# MDT-SF21026-R4-CDs.pdf Markup Summary

RD03

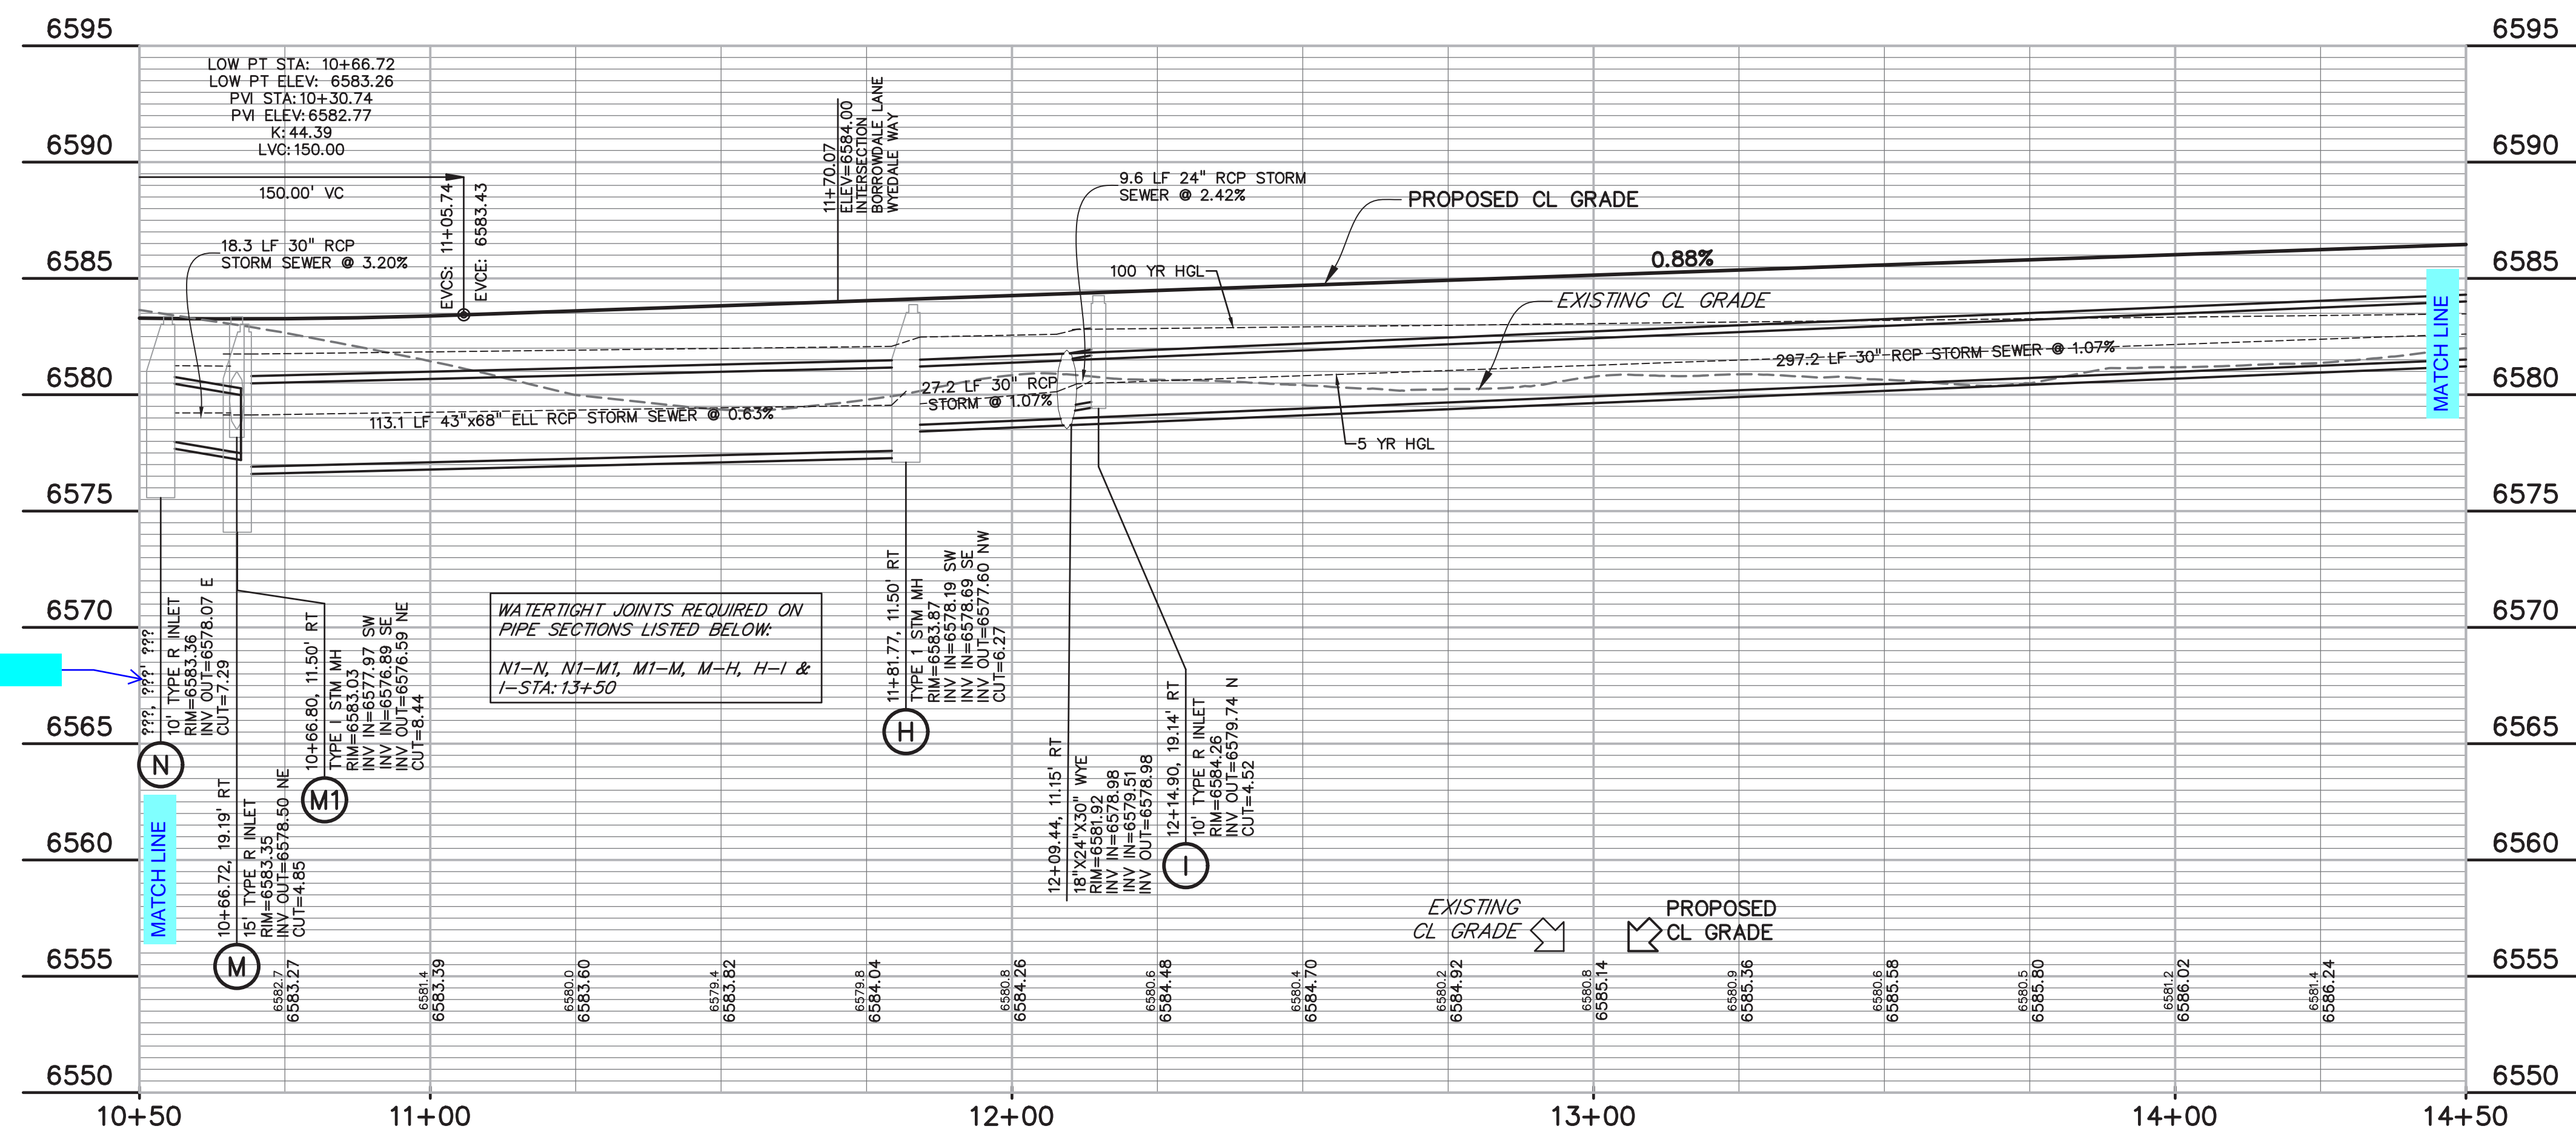
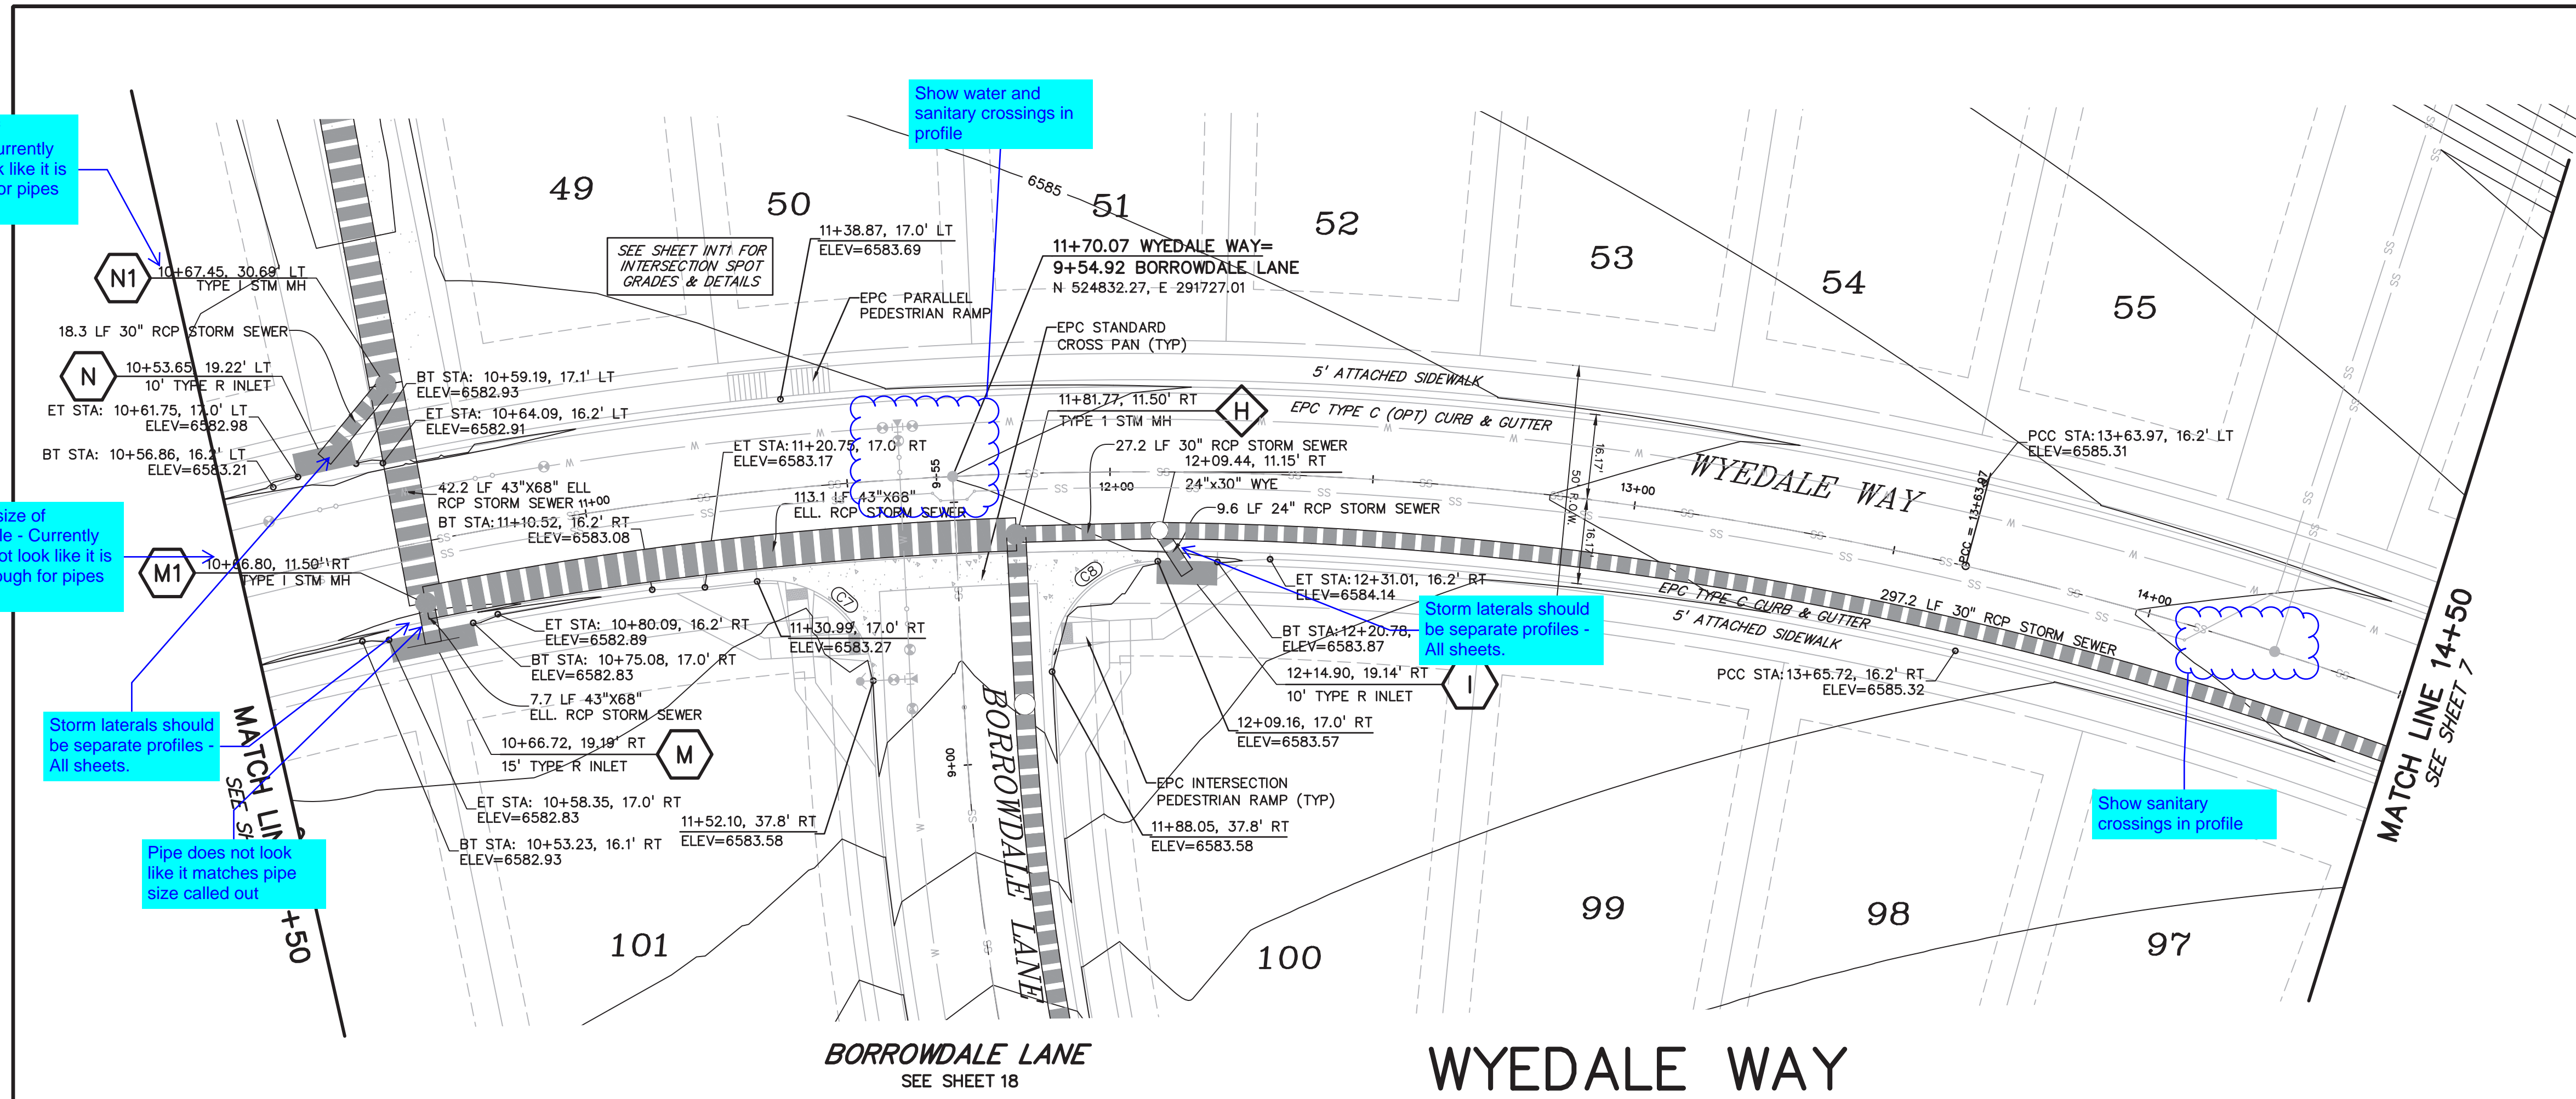
Storm laterals should be separate profiles - All sheets.

Remove all storm lateral information in profile, All sheets.

Label clearance between water and storm

RD09

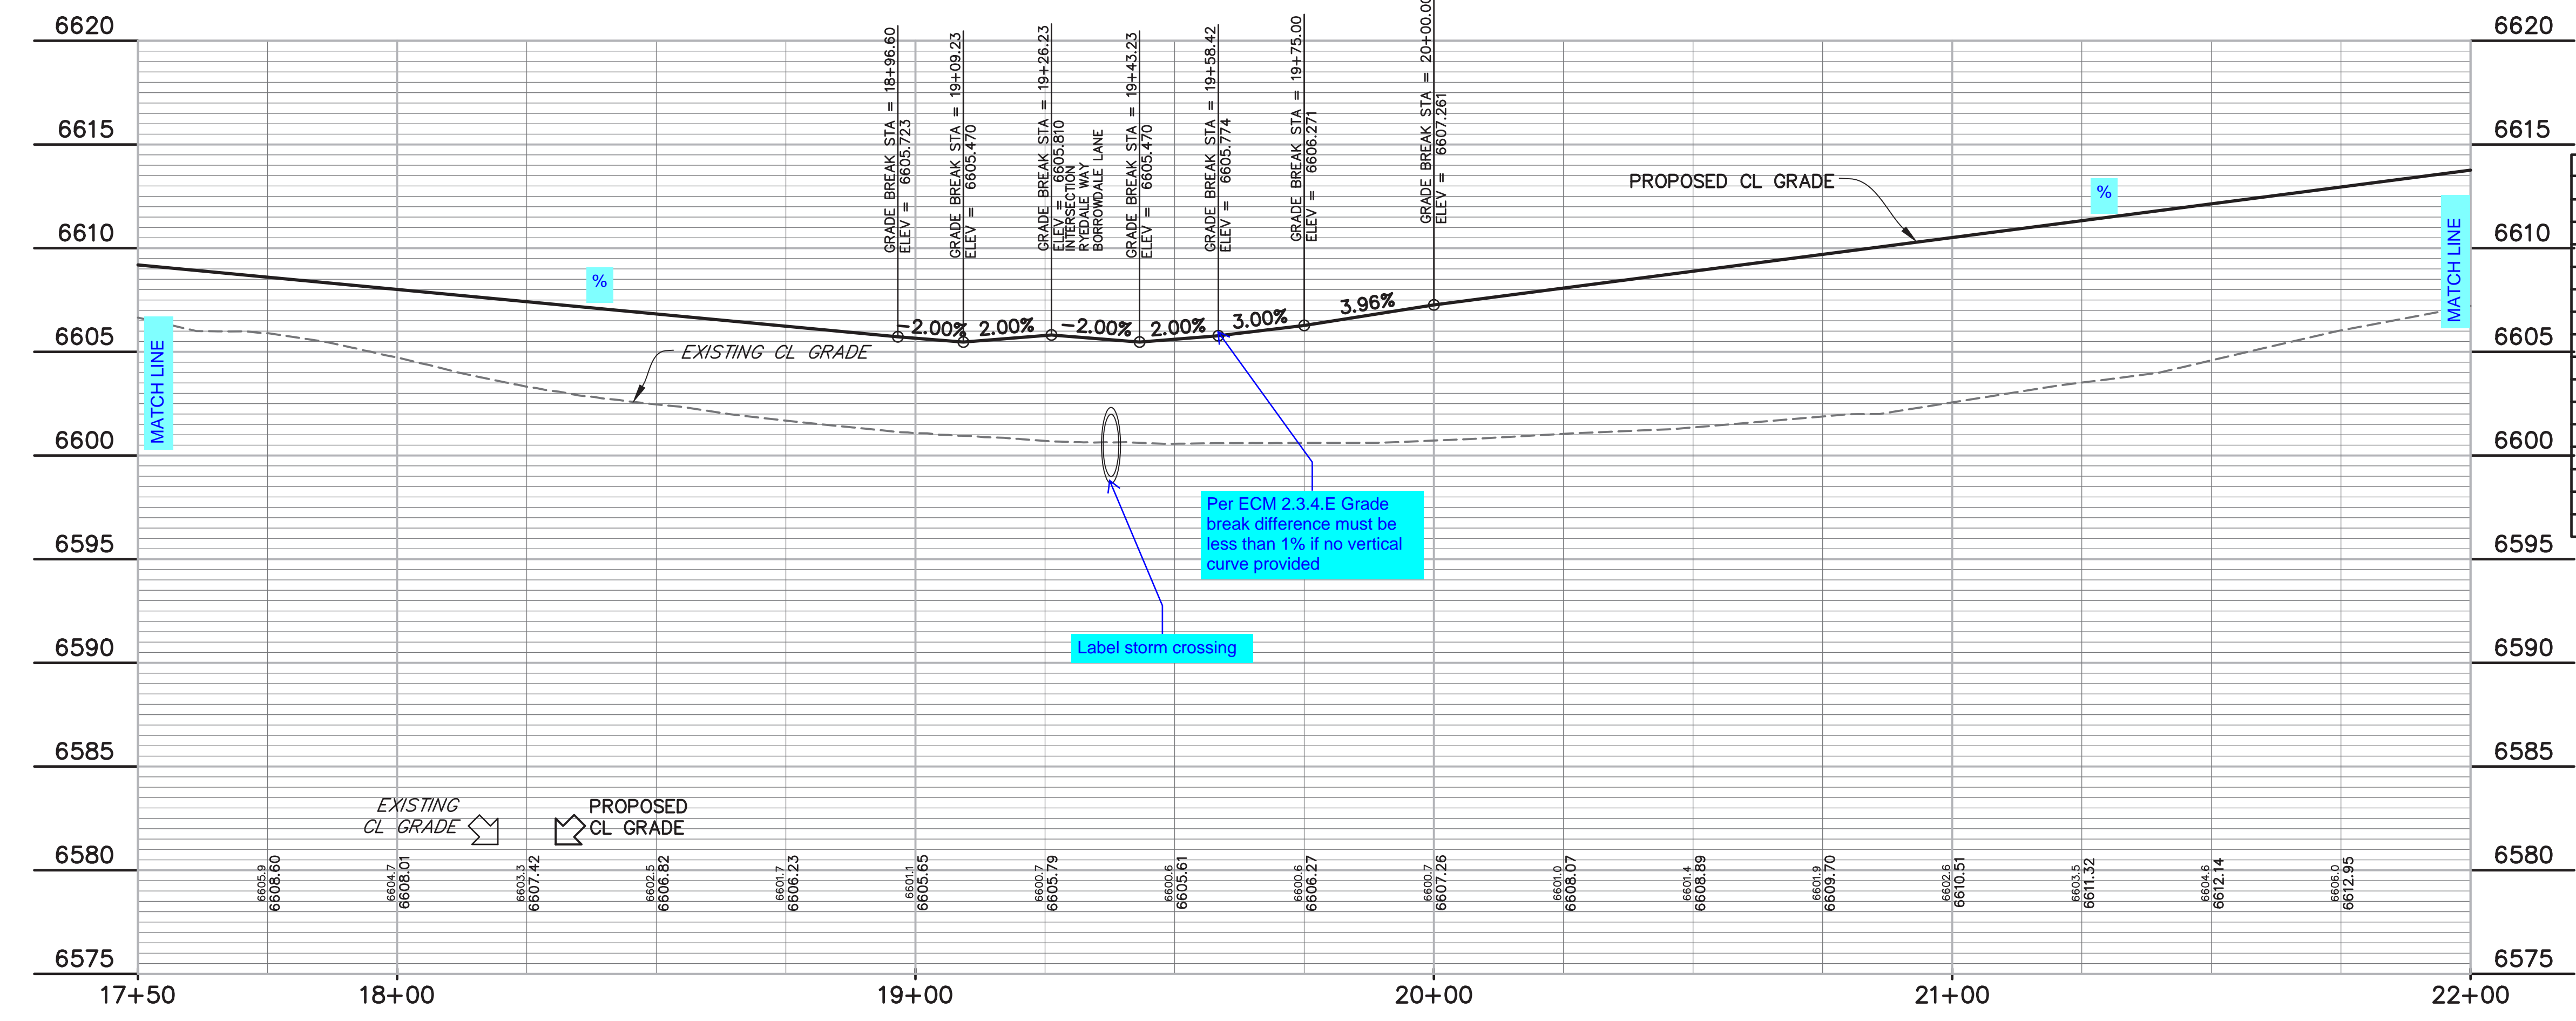
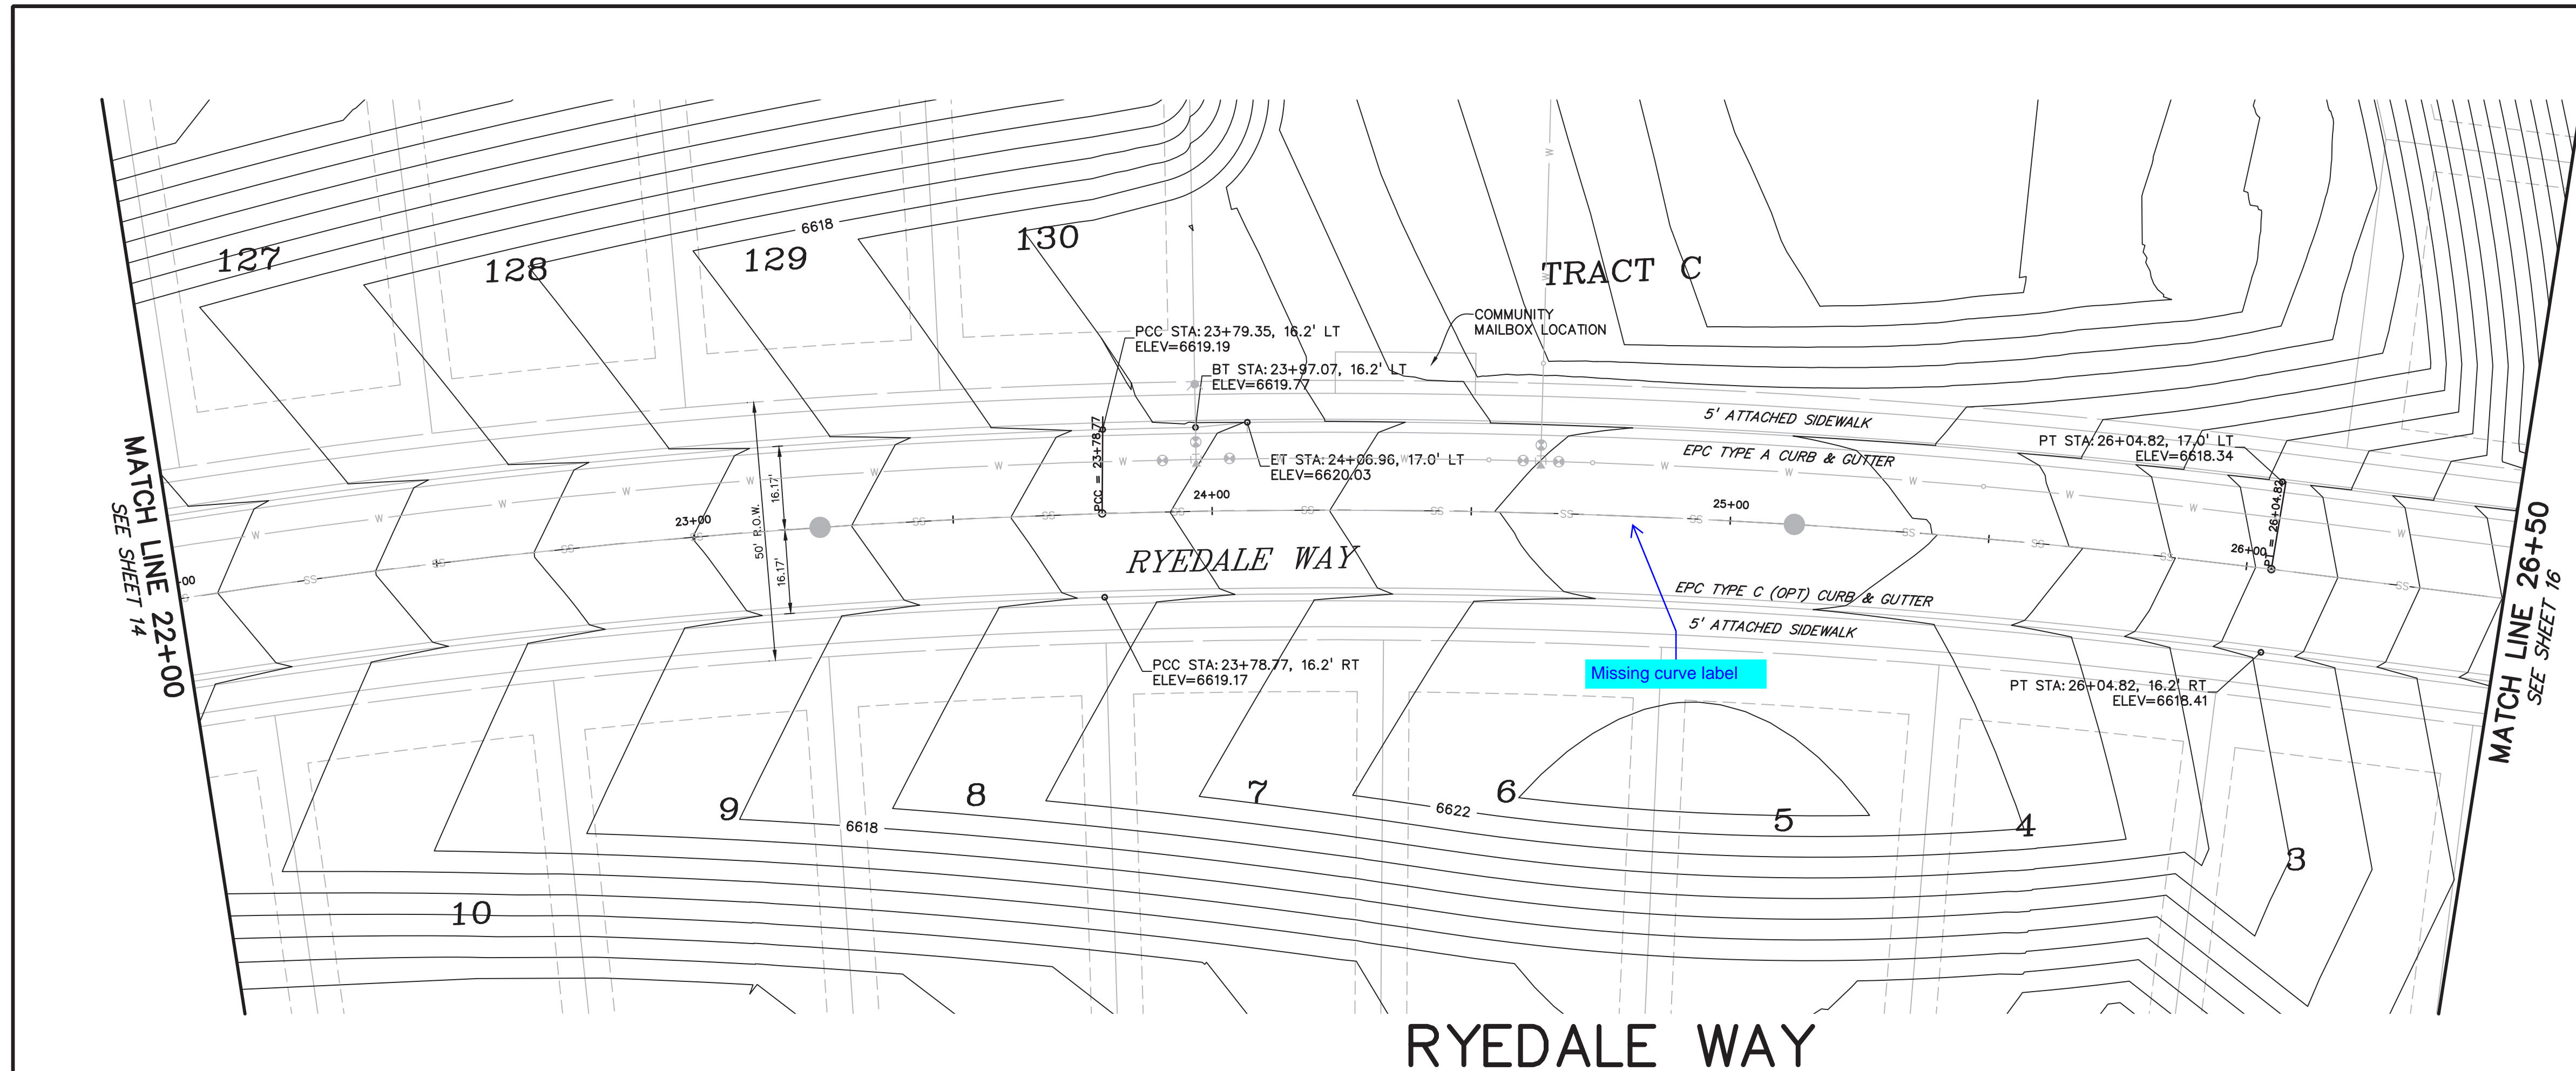
Label cover over storm
